Local Policing Support Team

Our Ref: LM/ARU/20/08A

RE: Land at the Southern End of Cinders Lane Cinders Lane Yapton BN18 0JJ

Thank you for your correspondence of the 17th March 2020 advising me of a planning application for Approval of reserved matters following the grant of Y/32/17OUT for the erection of 19 No. dwellings. This application also lies within the parish of Climping & affects a Public Right of Way at the above location, for which you seek advice from a crime prevention viewpoint.

SITE LAYOUT | PROPOSED DEVELOPMENT AT:
Land at Southern end of Cinders Lane
Yapton
BN18 0JJ
FOR
CRAYFERN HOMES LIMITED
Scale : 1:200 @ A1 Date : JAN 20
Drawing No : 97.17.P100 A

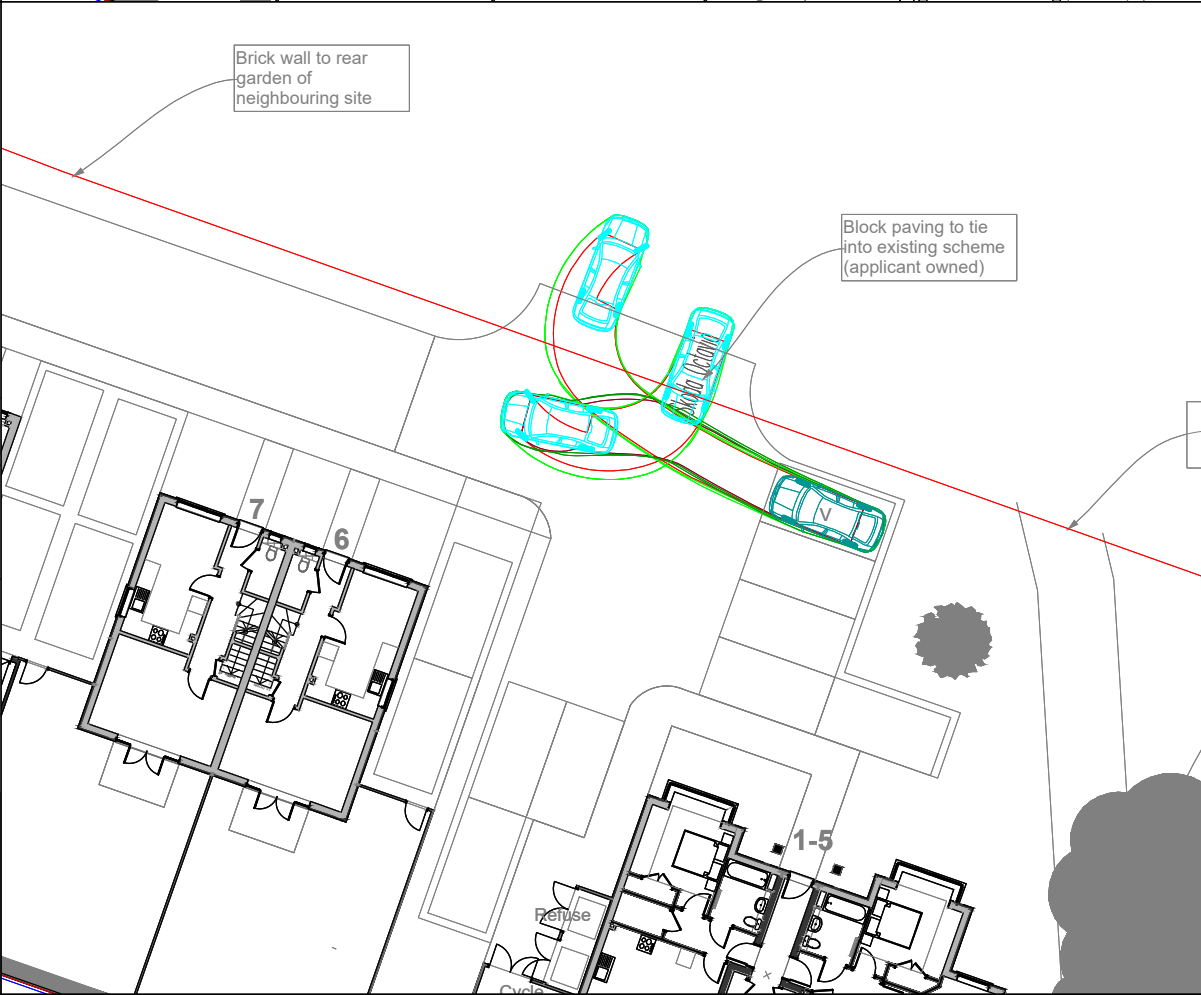
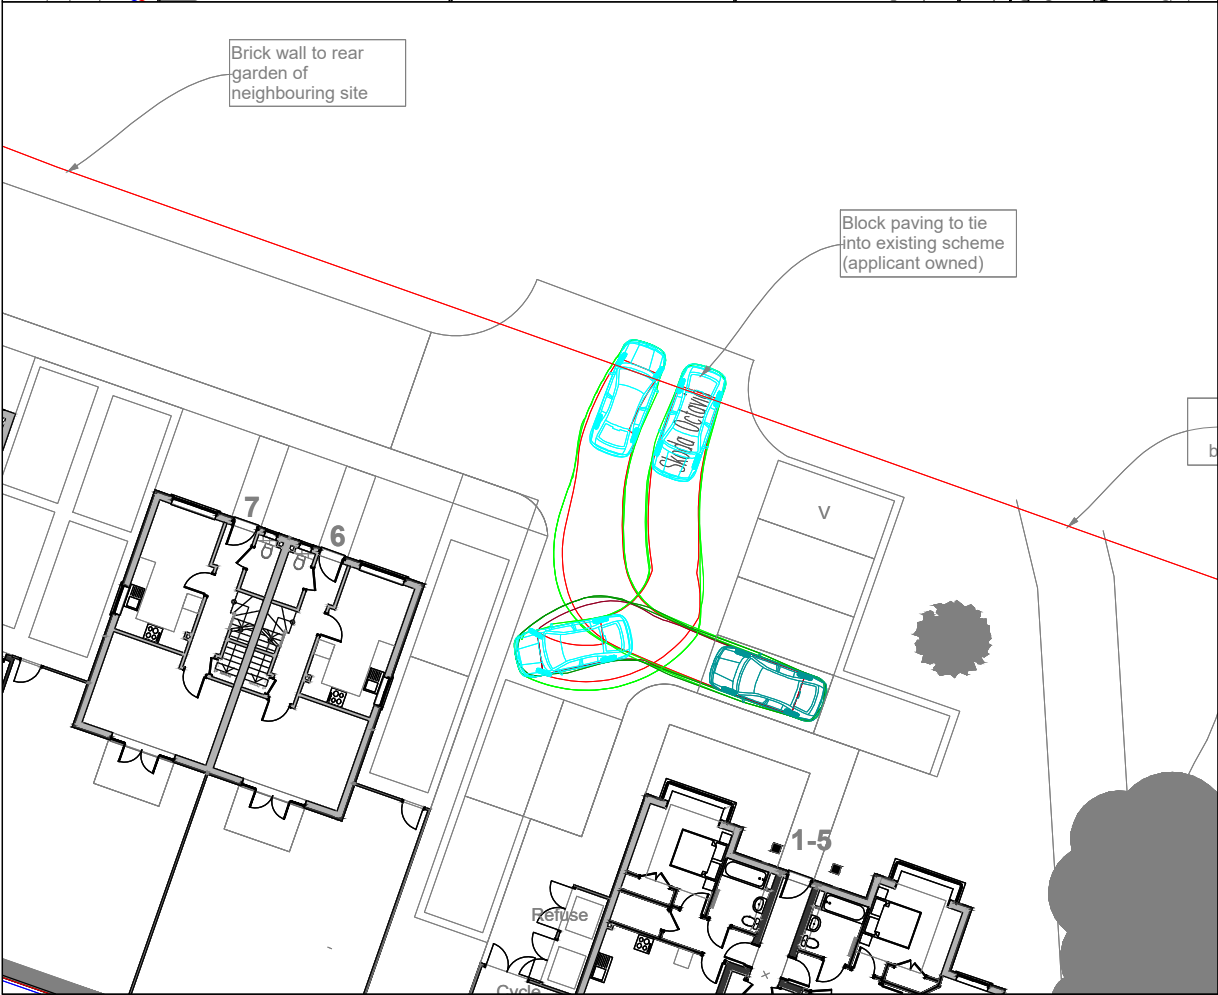
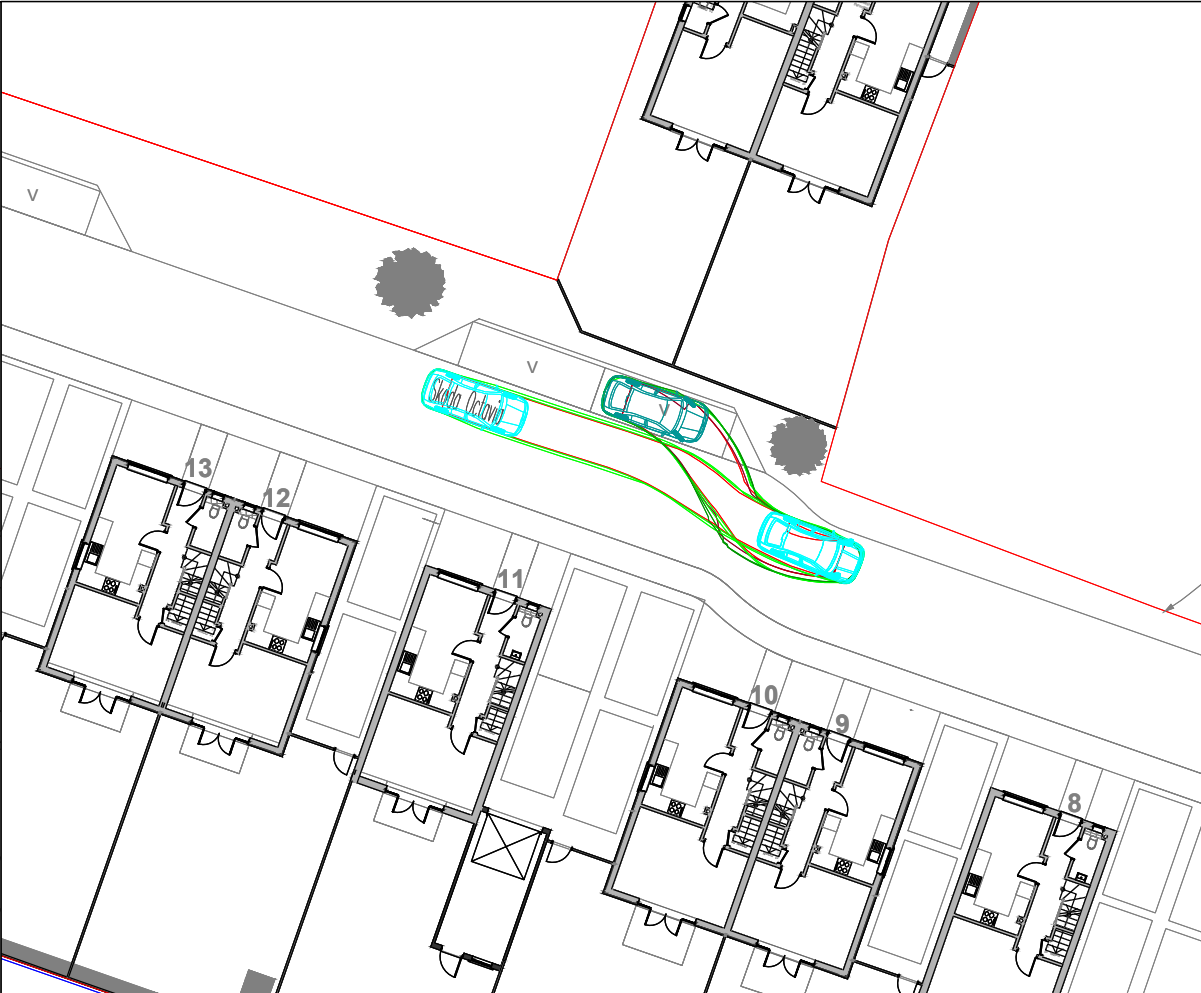
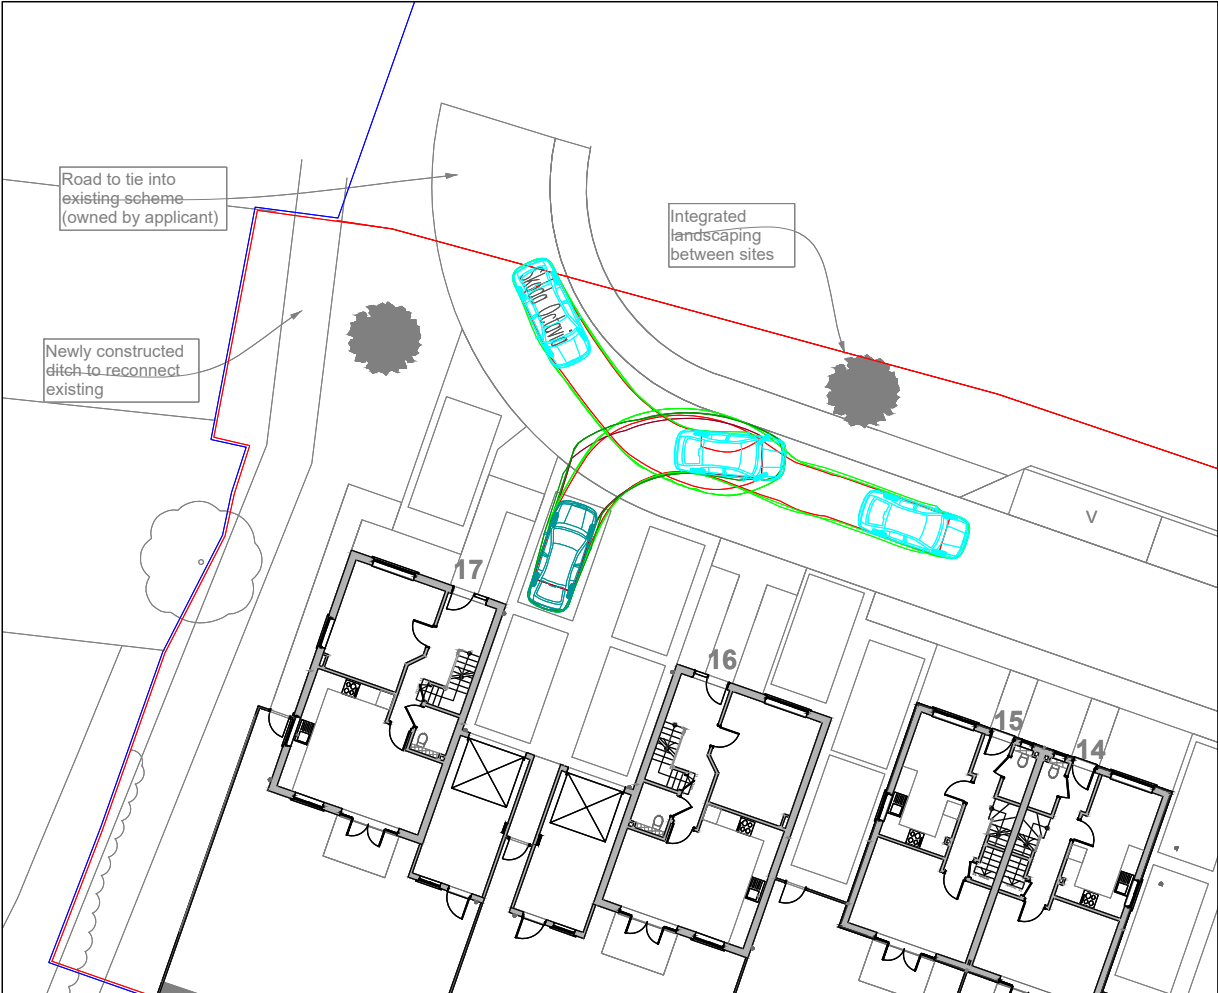
The development in the main has outward facing dwellings with back to back gardens which has created good active frontage with the streets and the public areas being overlooked, this design has all but eliminated the need for vulnerable rear garden pathways.

Where communal parking occurs it is important that they must be within view of an active room within the property. An active room is where there is direct and visual connection between the room and the street or the car parking area. Such visual connections can be expected from rooms such as kitchens and living rooms, but not from bedrooms and bathrooms. Gable ended windows can assist in providing observation over an otherwise unobserved area.

I refer the applicant to SBD Homes 2019 Chapter 8 which refers to layout of roads and footpaths. Footpath design - 8.9 states that public footpaths should not run to the rear of, and provide access to gardens, rear yards or dwellings as these have been proven to generate crime. 8.10 Where a segregated footpath is unavoidable, for example a public right of way, an ancient field path or heritage route, designers should consider making the footpath a focus of the development and ensure that they are: • as straight as possible; • wide; • well-lit • devoid of potential hiding places; • overlooked by surrounding buildings and activities; • well maintained so as to enable natural surveillance along the path and its borders.

With regards to the cycle stores within the development I refer the applicant to SBD Homes 2019 Chapter 56 Secure external storage facilities and bicycle security. 56.1 states that external containers specifically designed for the secure storage of bicycles and other property must be certificated to one of the following minimum security standards: • LPS 1175 Issue 7.2:2014 Security Rating 1 (or above); or • LPS 1175 Issue 8:2018 Security Rating 1/A1 (or above); or • STS 202 Issue 7:2016 Burglary Rating 1 (or above); or • LPS 2081 Issue 1.1:2016 Security Rating A; or • Sold Secure (Bronze, Silver or Gold).

Finally, lighting throughout the development will be an important consideration and where it is implemented it should conform to recommendations within BS 5489-1:2013

SBD considers that bollard lighting is not appropriate as it does not project sufficient light at the right height making it difficult to recognise facial features and as a result causes an increase in the fear of crime.
